# EL PASO COUNTY

## DEPARTMENT OF PARKS AND COMMUNITY SERVICES

**Subject: FourSquare at Sterling Ranch East Filing No. 1 Final Plat, Submittal #3 – Final Comments (SF-22-036)**

FOURSQUARE AT STERLING RANCH EAST
FILE NO. 1
PRIVATE PERMANENT CONTROL MEASURE
PRIVATE EXTENDED DETENTION BASIN PLAN SET

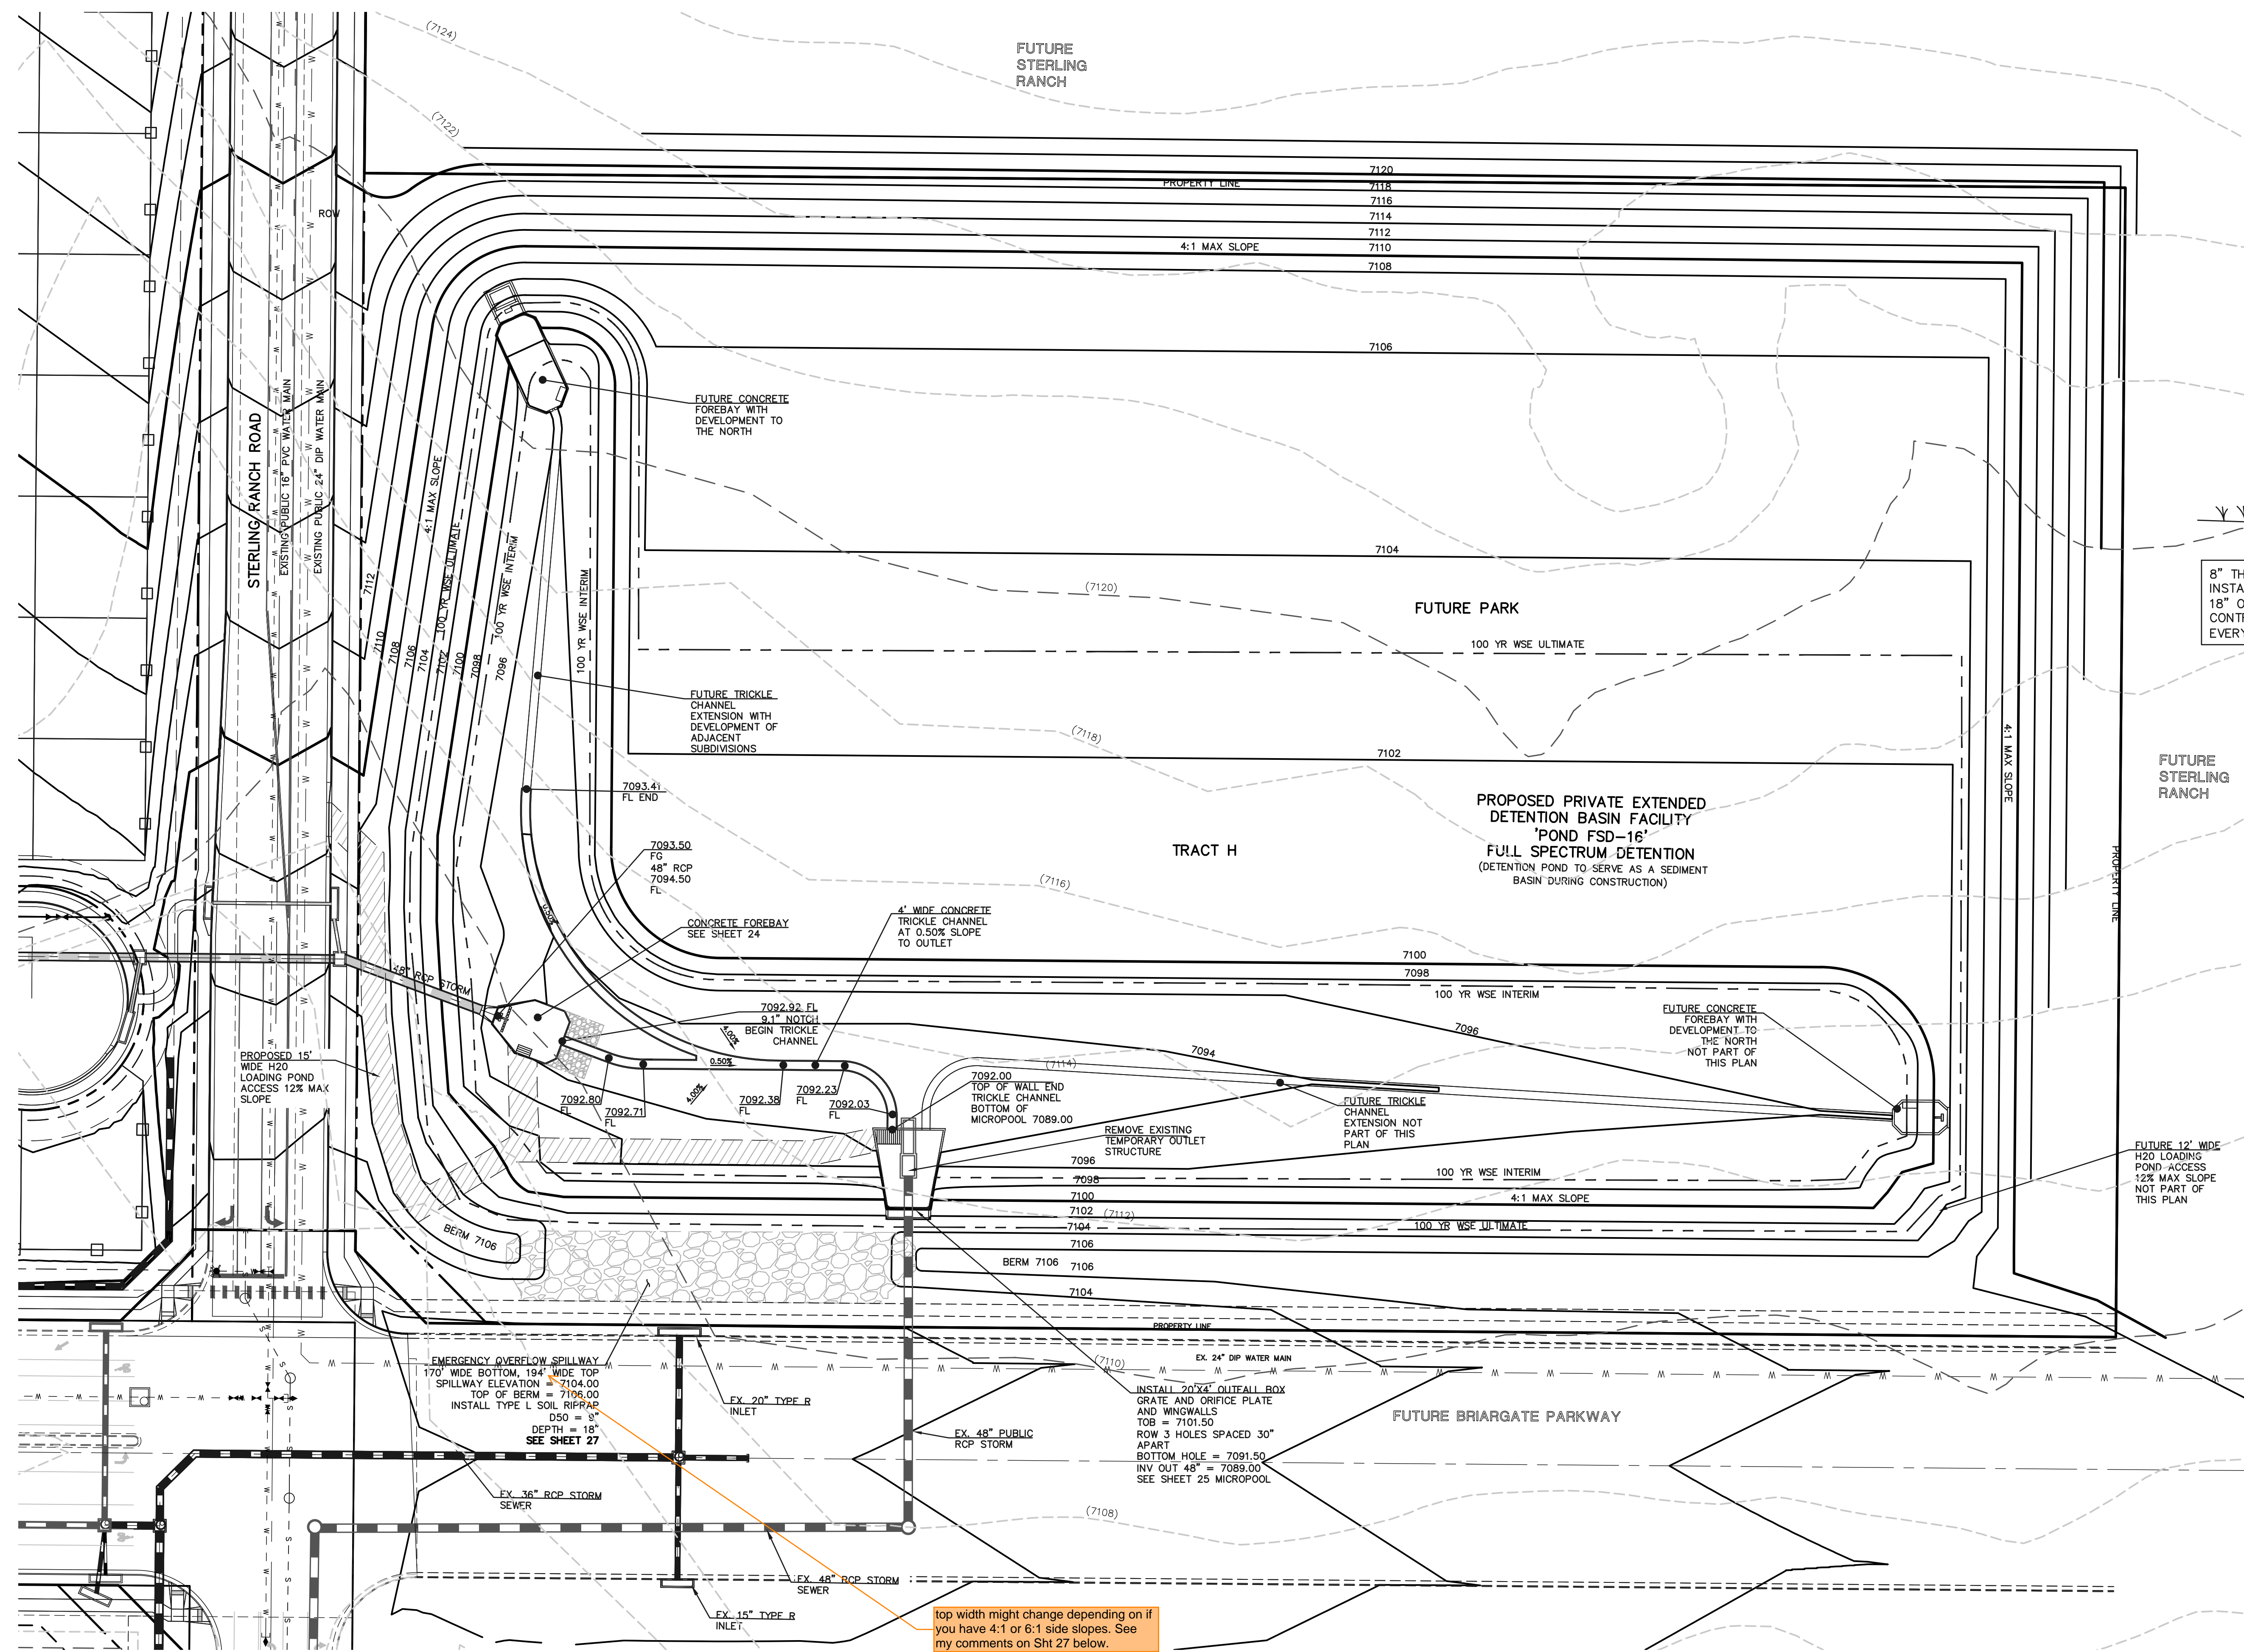
Staff is pleased the FourSquare at Sterling Ranch East Filing No. 1 Final Plat contains a large percentage of passive-use park and open space areas, however, the inclusion of the large regional stormwater detention facility in the open space calculations as a dual-purpose drainage and recreational facility is concerning. As noted above, stormwater facilities may only comprise 10% or less of the open space calculations, whereas Tract I comprises 30.5% of the total project area and as noted above, 68.5% of the available open space.

Furthermore, Parks staff highly discourages the construction of recreational facilities in an active stormwater detention facility, especially one of this size and magnitude. In order to maintain a hazard-free recreational environment, a multi-use turf field located at the bottom of the detention facility would need to be adequately fenced from the concrete trickle channels, forebays, and outlet works, thus disrupting the overall efficiency of the detention facility itself.

Because Tracts A through H, at 5.17 acres, comprise over 14% of the total project area and therefore meet and exceed the PUD 10% open space requirement, staff recommends the applicant remove the regional stormwater detention facility from the open space calculations in order to conform to the recommended guidelines of the Land Development Code.

Staff does, however, encourage the applicant to construct the trail and trail-related amenities around the upper perimeter of the stormwater detention facility, keeping user safety in the forefront of plan design. Staff also encourages the applicant to plan and develop active-use amenities within the 2.57-acre neighborhood park, which could include playgrounds, picnic tables and pavilions, and perhaps exercise areas. These types of amenities would allow for a wide variety of recreational choices to users of all age groups and abilities. Lastly, staff recommends fees in lieu of land dedication for regional and urban park purposes, to be paid upon the recording of the forthcoming final plats.
